Champions Quarry - Modification 3 (PA 09_0080 MOD 3)

I refer to your email dated 6 June 2017 inviting the Environment Protection Authority (EPA) to provide comment on the proposed modification to the project approval for Champions Quarry (PA 09_0080). The EPA appreciates the opportunity to comment and apologises for the delay in responding.

Figure 3: Proposed layout of sand washing plant and water treatment system

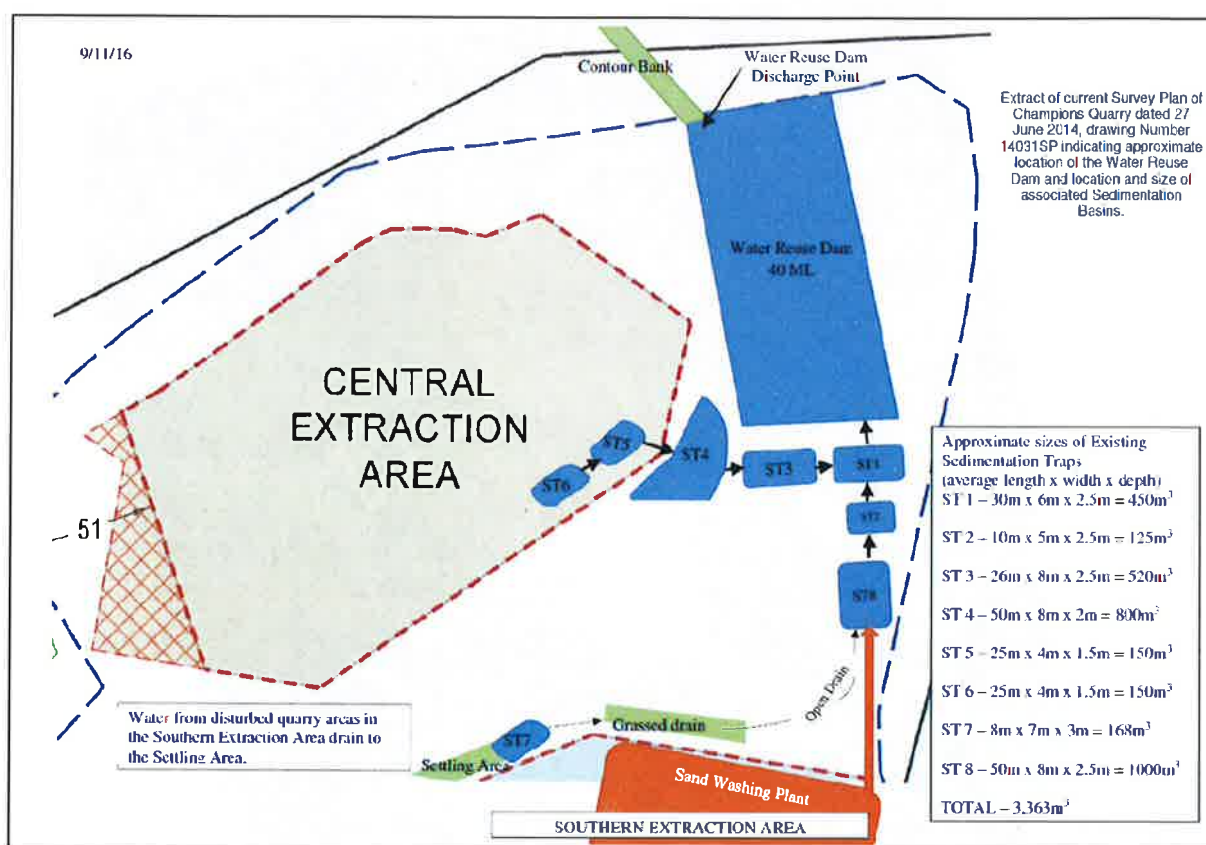
- Relocation of a proposed sand washing plant from previously assessed location of the CEA to the northern section of the northern quadrant of the SEA
- Increase of bund height to about 6 metres to screen the plant from receivers
- Removal of topsoil and overburden over a 1 hectare area to allow establishment of the sand washing plant and associated and stockpiles.
- Installation of additional sediment control traps before the water reuse dam.

However, the current Water Management Plan does not include impacts from the sand washing plant and the increased disturbed area from establishment of the sand washing plant and stockpile area. A revised Water Management Plan incorporating the new activity and disturbed area should be a required.
